From: [David O'Connell](#)
To: [Michelle Niles](#)
Subject: RE: Notice of Modification Request - Casuarina Town Centre Project Approval (MP 06_0258 MOD 12)
Date: Tuesday, 11 December 2018 3:55:01 PM
Attachments: [image007.png](#)
[image008.jpg](#)
[image009.jpg](#)
[image010.png](#)
[image011.jpg](#)
[image012.jpg](#)
[image013.png](#)
[image014.jpg](#)

The proposal seeks to separate a medium density lot into two lots. Proposed lot 1 is an existing car park and proposed lot 2 is an existing multi dwelling development. A request for information was sent to the applicant (via Department of Planning) demonstrate that by separating the medium density lot into two lots that each lot can be adequately serviced for any future dwelling construction. In particular proposed Lot 1 as this lot only has an existing car park and is not serviced (note there has been numerous queries to provide a dwelling on the existing car park area).

Water & Wastewater has reviewed the Further Information details provided by Planit Consulting regarding the mod to subdivide the existing carpark lot from the existing lot parcel.

PROPOSED SUBDIVISION PLAN

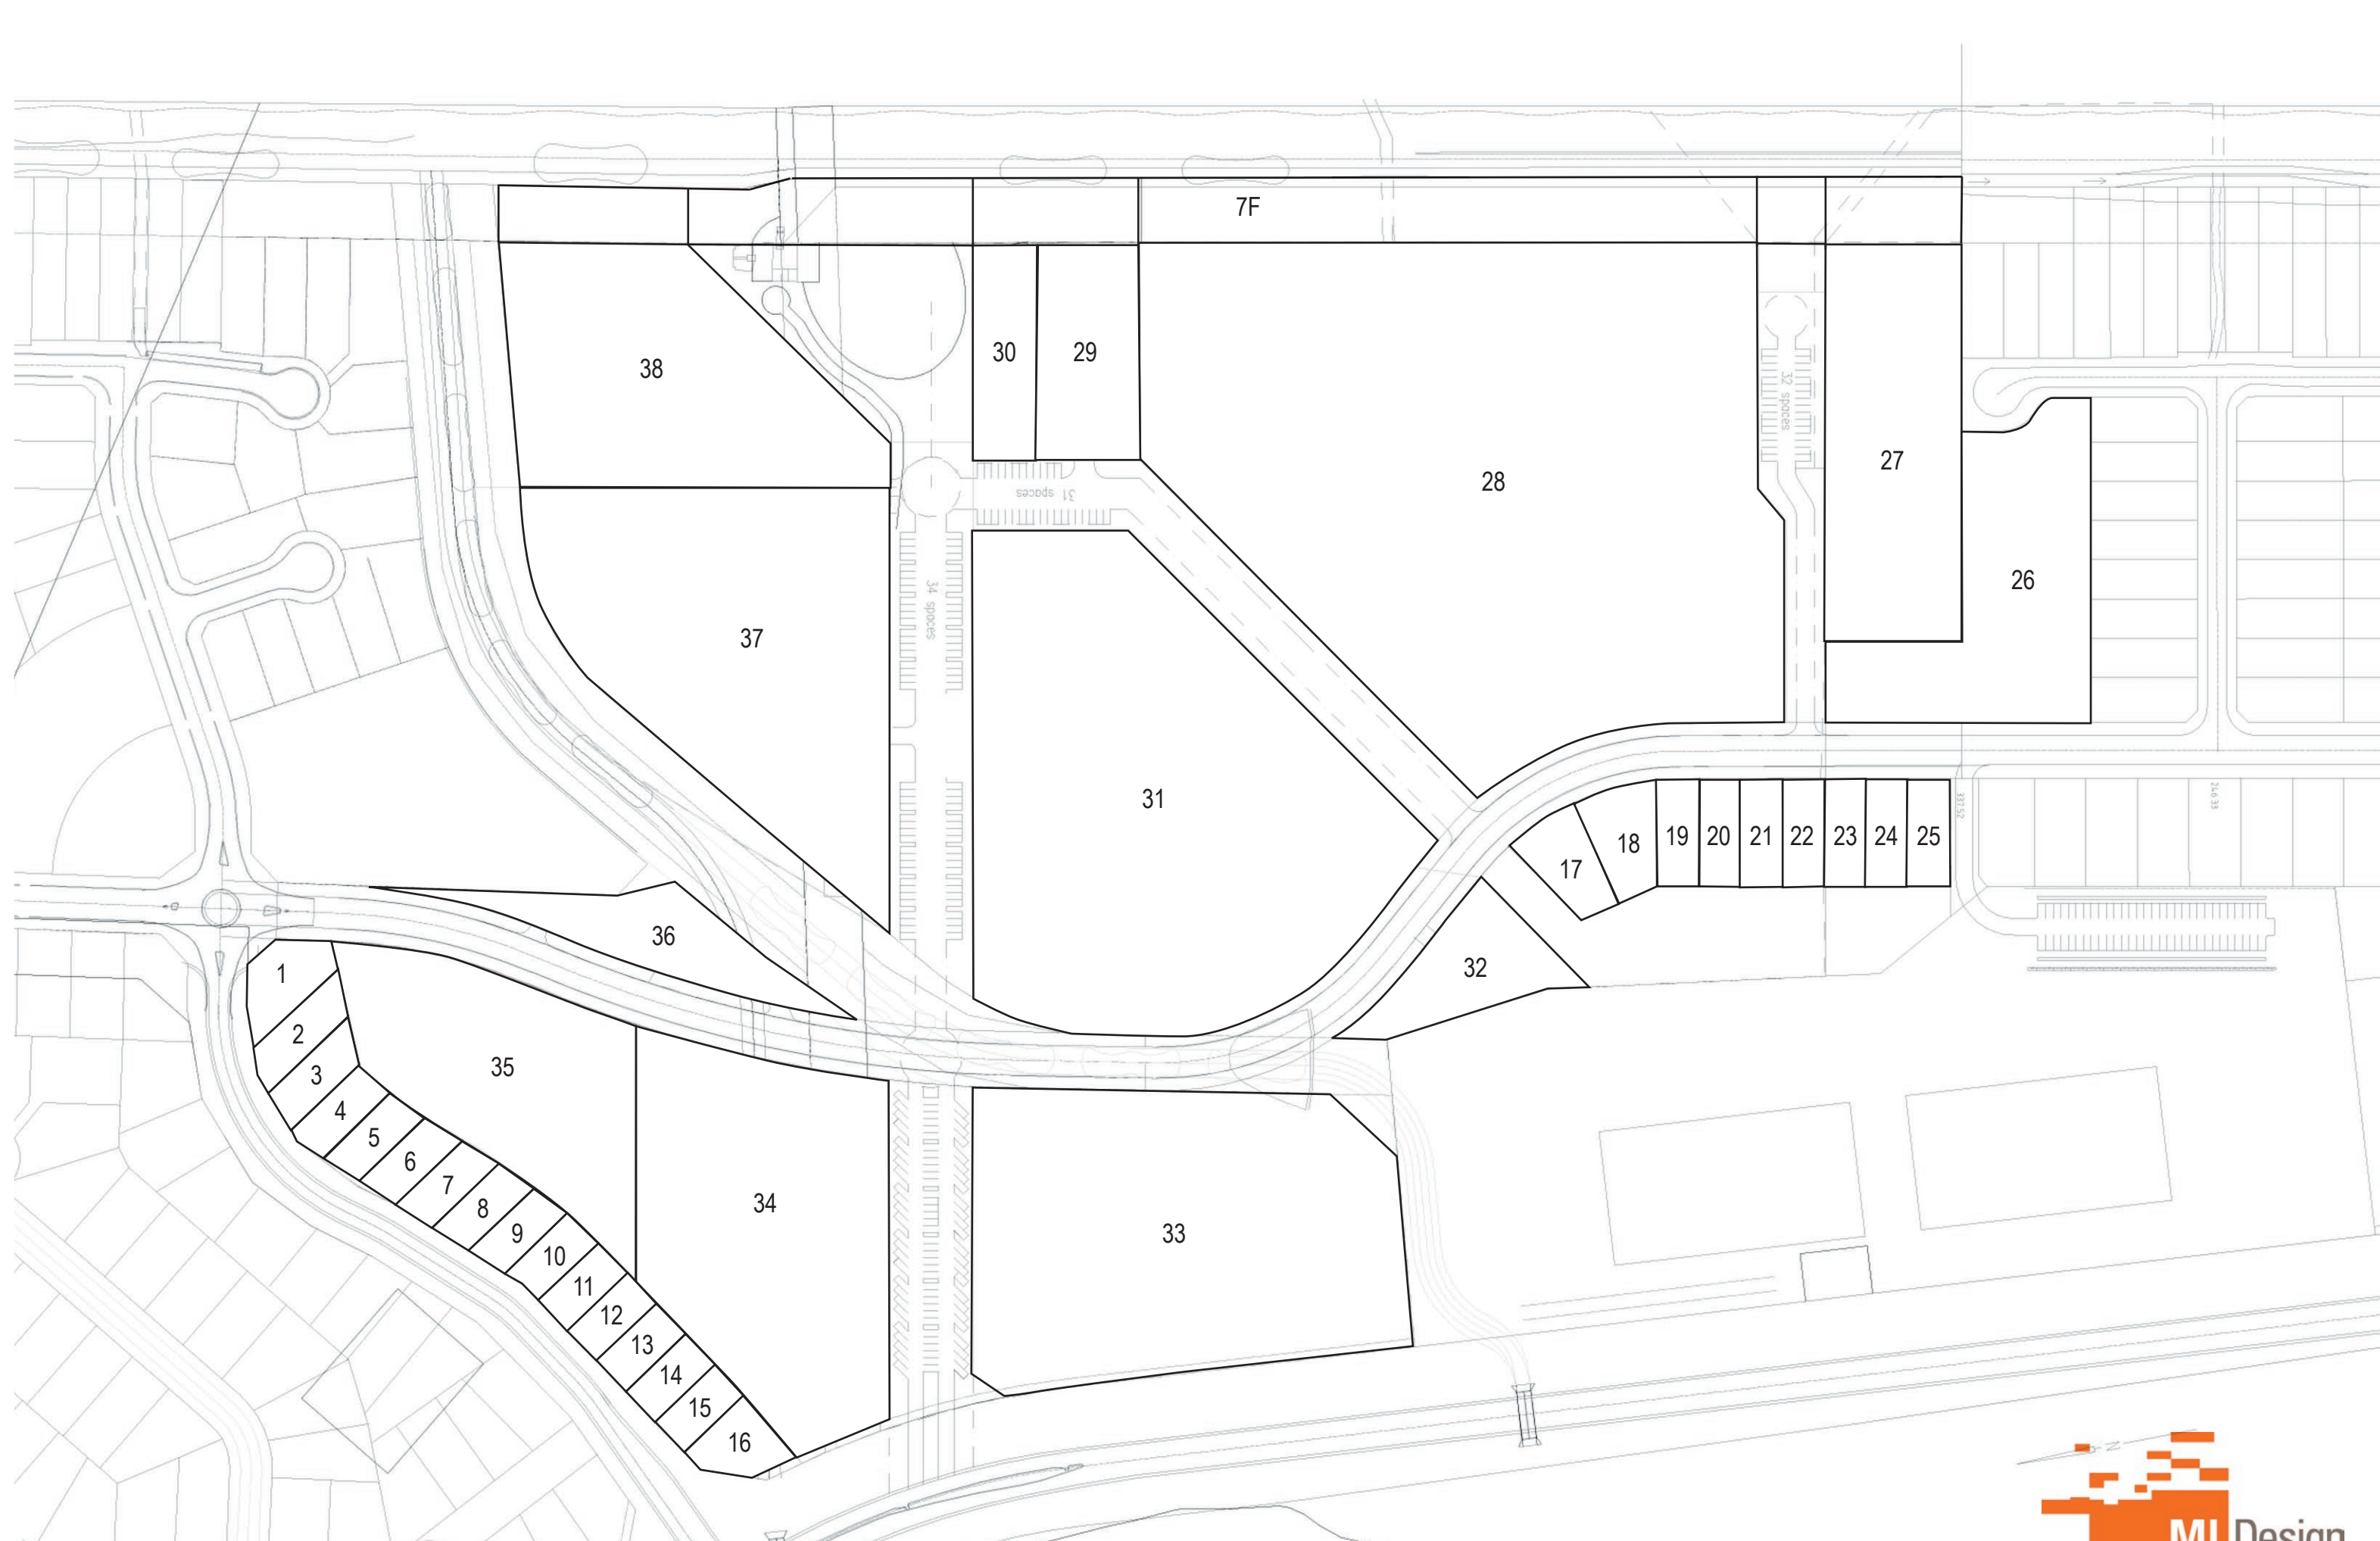
1. The applicant has referenced a drawing in their appendix A - "Proposed Subdivision Plan dated 10/10/2006 by MLDesign" as an approved plan indicating that the car parking area was a separate lot to that of the medium density lot. All consent approvals do not indicate that this drawing was approved as part of the original consent. Clarification may be required from the applicant where this drawing was approved as part of the consent.

Response: The Medium density lot (totalling 8679m²) has always been intended for medium density development as part of Stage 1C whilst the Car Parking Lot (totalling 928.2m²) contains a constructed car park, as demonstrated from Concept Approval through all modifications. This car parking allotment is maintained as intended for the provision of car parking spaces for the Casuarina Town Centre locality. The Stage 1C Lot (3) is for medium density development which has since been incorrectly registered on title to include the medium density allotment and the car parking allotment as one parcel of land and registered as Lot 16 in DP1198266. Which occurred as part of Mod6 and the introduction of the additional sub-stage 1C. The car parking allotment is most recently demonstrated as a separate parcel and under a separate stage (being Stage 1A) on the approved plans for Mod 6 (titled *Development Staging Plan* By Newton Denny Chapelle dated 17/10/13 with ref. 12/111B), is shown again in the plan set for Mod 7, as well as the concept approval plan set.
